From: Ian Brewster
Sent: 04 June 2013 11:47
To: Janice Chapman
Subject: AW/97/13/T Land Adj to 9 Acorn End Aldwick PO21 4JA

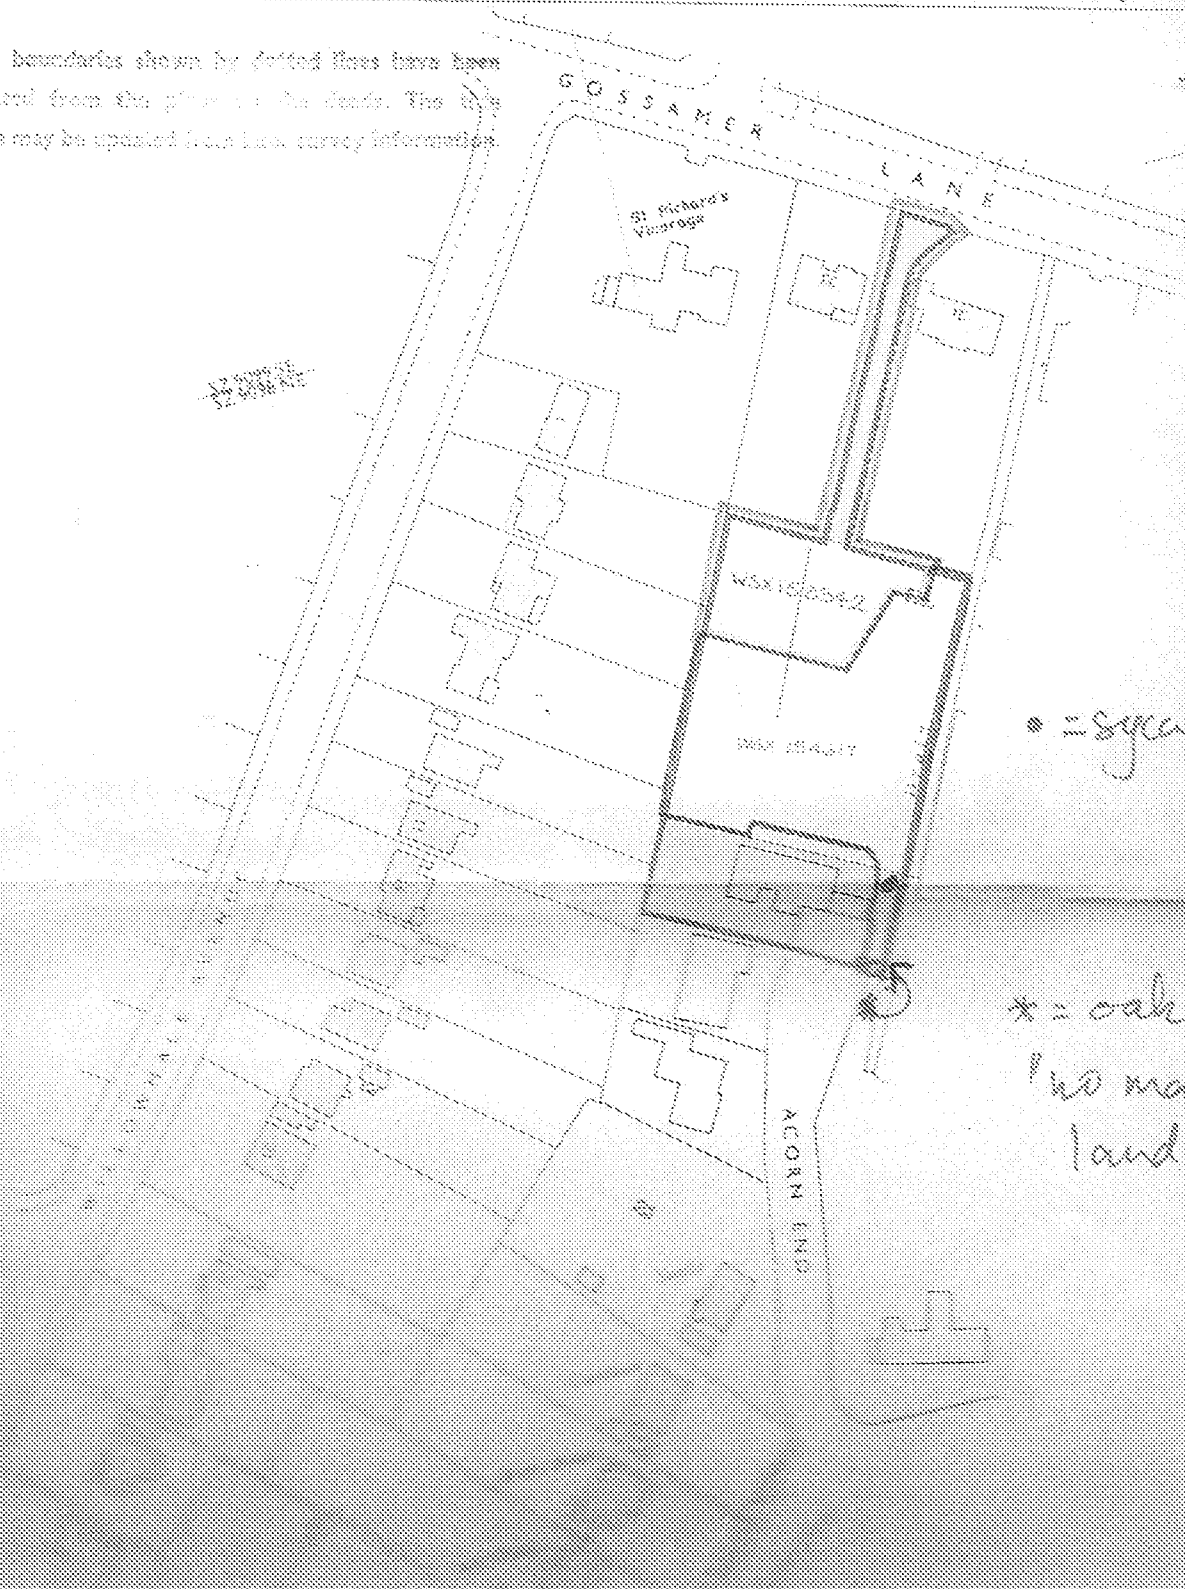
I met with the lady owner and her tree surgeon yesterday regarding the two trees, the Sycamore located close to her property and the English Oak overhanging the highway. I suggested that it would be appropriate to allow for the reduction of the Sycamore sides by 2m (total 4m lateral prune) and 4m from its height. The English Oak low branches 'within a height of 10m of the road' overhanging the highway were inspected and the reduction of 3m was found to be acceptable, to help restore balance to an asymmetric crown shape. I spoke with the tree surgeon who agreed that this could be done to BS3998 (2010), leaving substantial side branch growths without abruptly cuts ends.
